DYLAN J. WILLIAMS BA (Hons), MSc, MA, M.R.T.P.I
Pennaeth Rheoleiddio a Datblygu Economaidd
Head of Service Regulation and Economic Development

Wylfa Newydd DCO Examination EN010007 - Deadline 7 Submission.

Post Hearing Note on Housing and Construction Workers Accommodation

Written submission of oral cases and post hearing Action Points

Figure 2-1 Indicative Construction Timeline

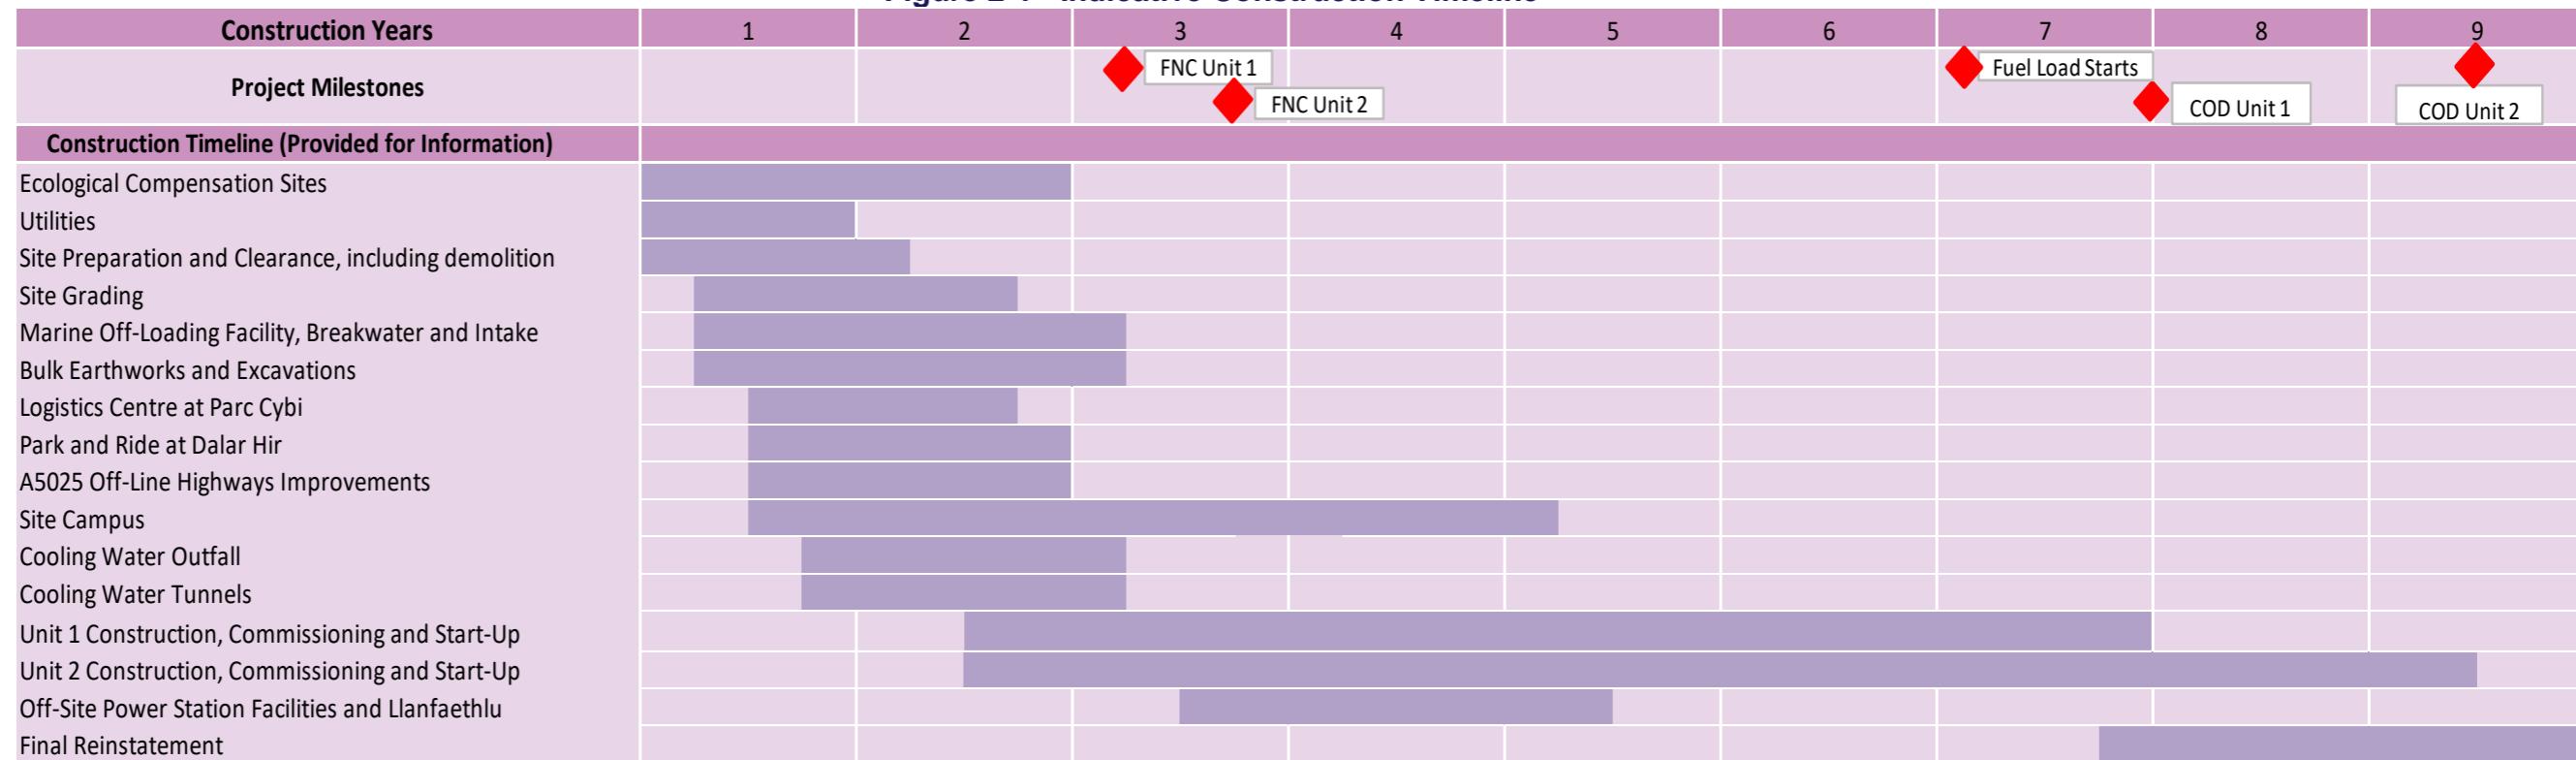
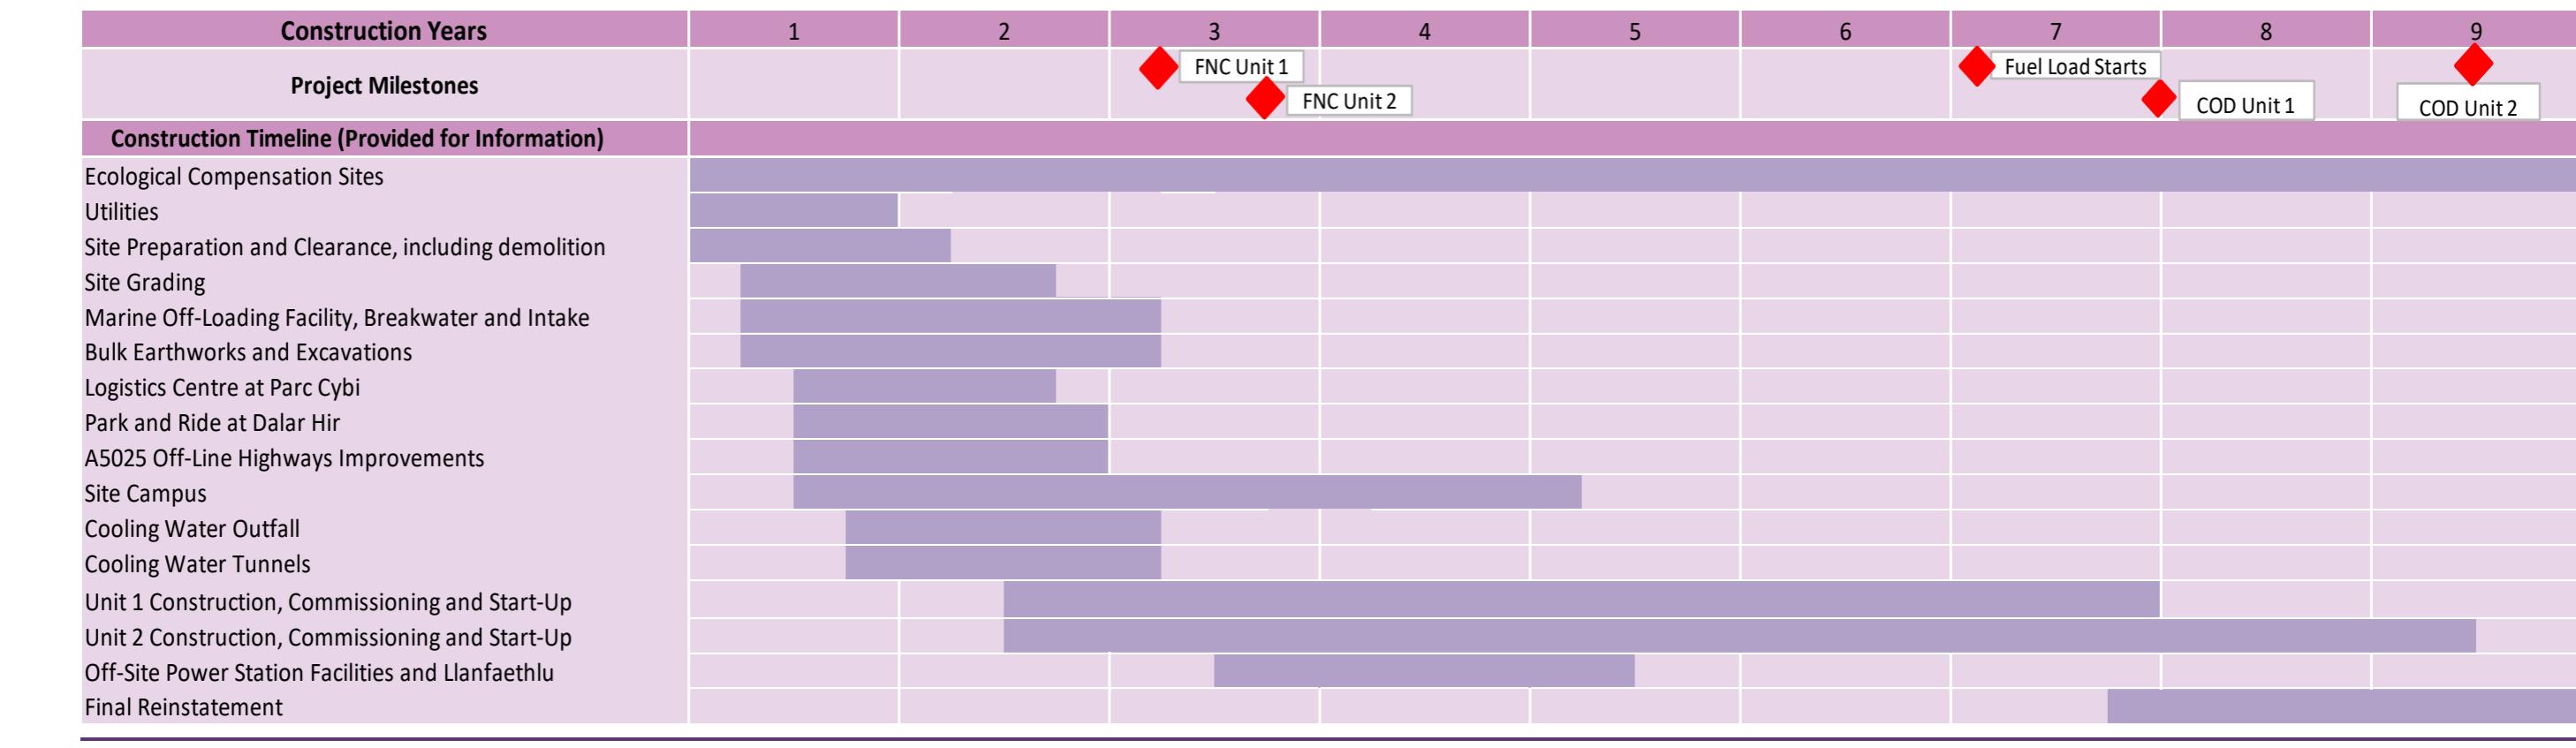
- 3.1.2 According to the Phasing Strategy [REP4-014 Figure 2-1] the Commercial Operational Date (COD) for reactor 2 is at the end of Q2 Y9. There will be approximately 5,500 construction workers still working on site at this time therefore the IACC required clarification on how these workers will be accommodated without having adverse impacts on existing accommodation [further detail on this is contained in the IACC's LIR REP2-068 section 5.6].
